ENG-SF22013-R1-CDs.pdf Markup Summary

Engineering Review
05/19/2022 2:44:59 PM
dsdrice
JedRice@epcd.com
(719) 536-7677
EPC Planning & Community
Development Department

DP02 PROFILE
STA 0+00.00 TO 8+74.96

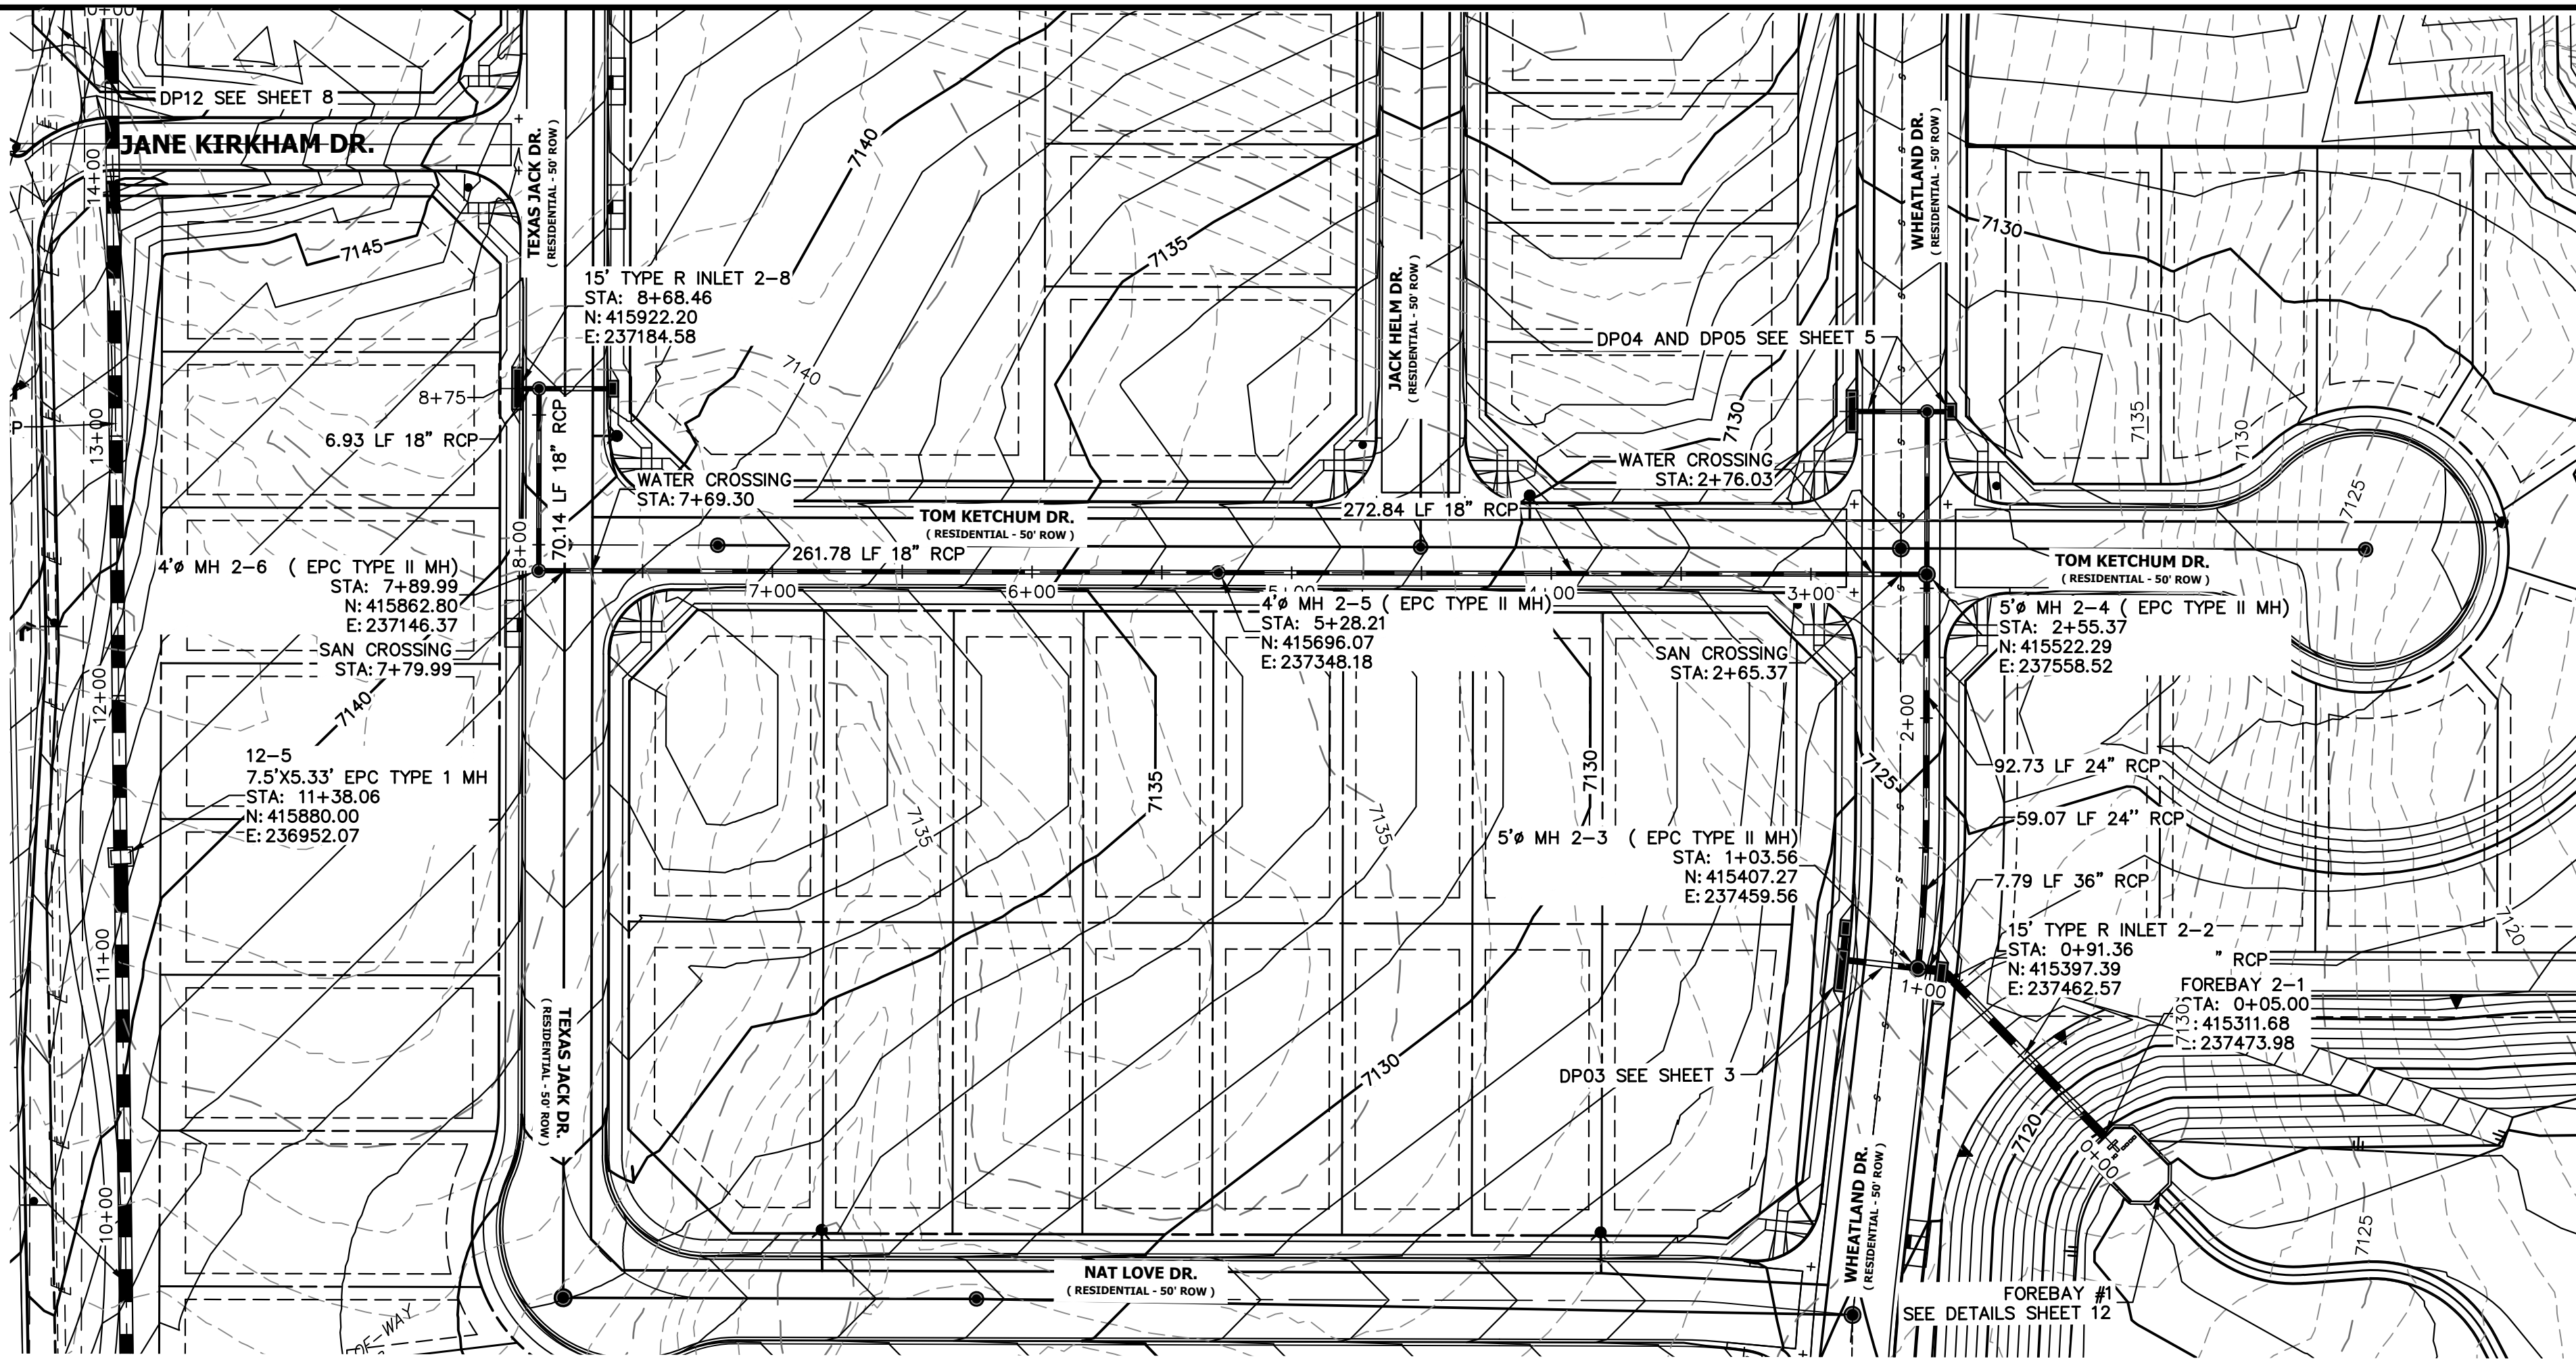
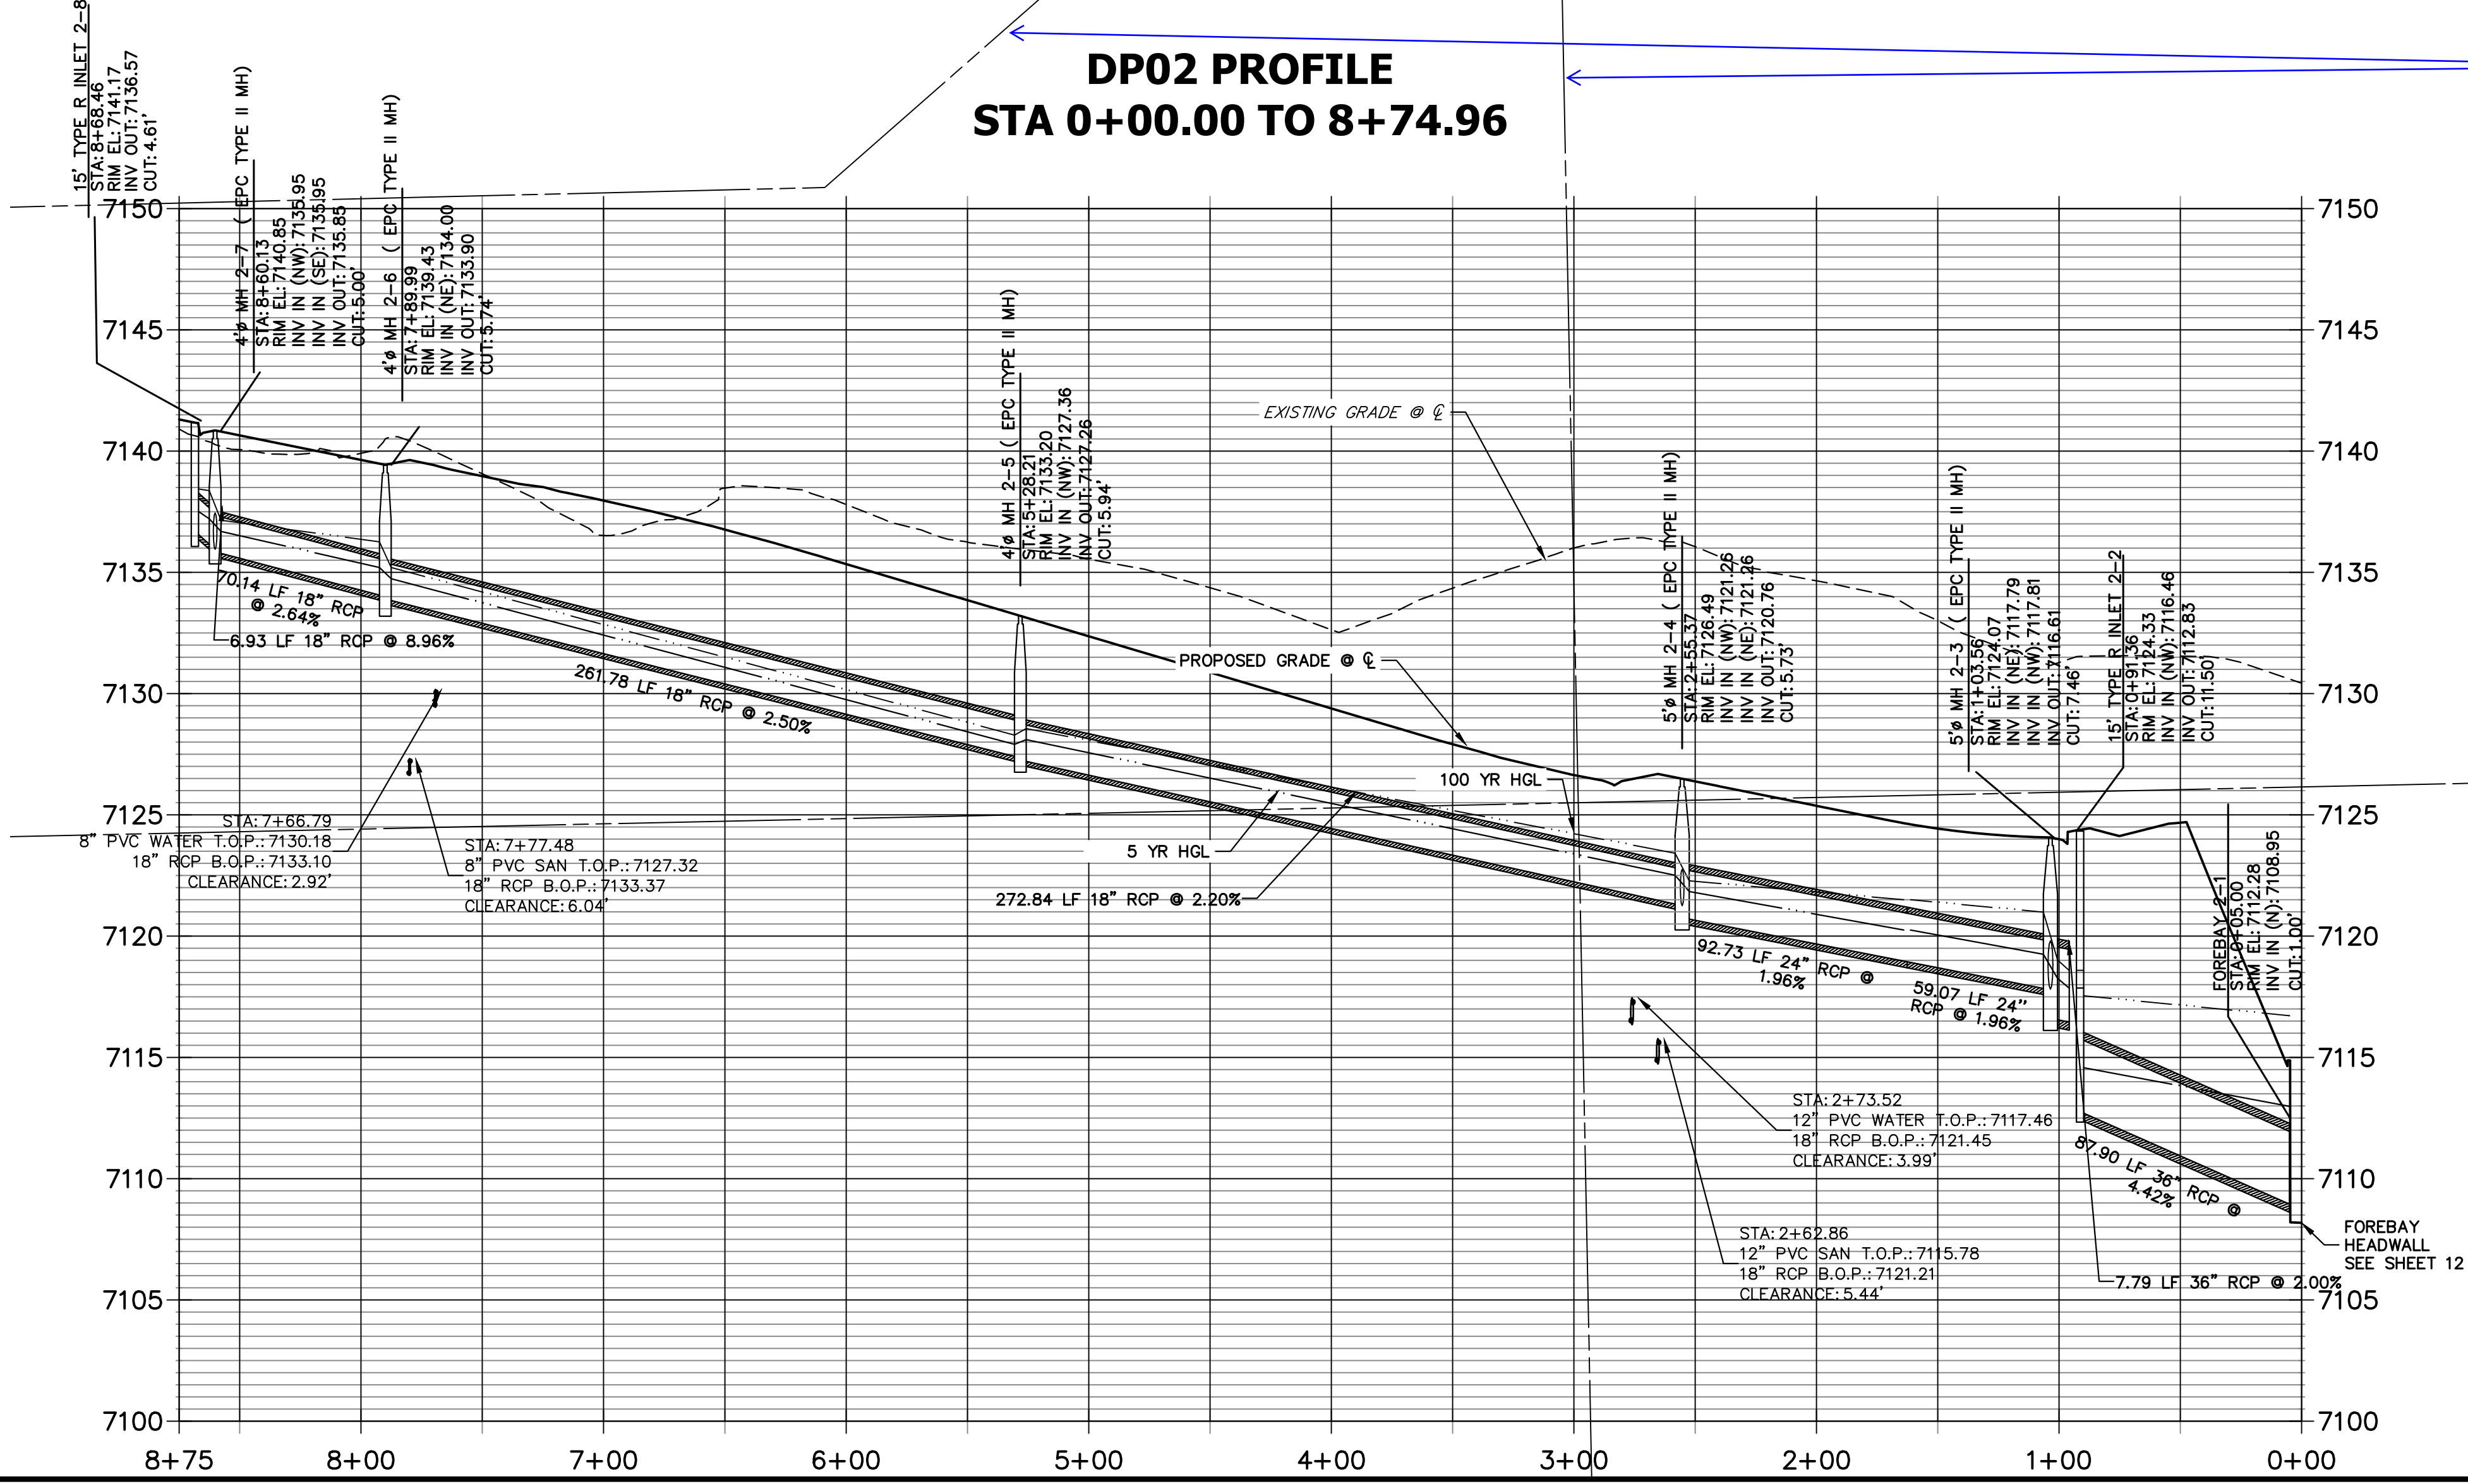
Show HGL on all storm drains
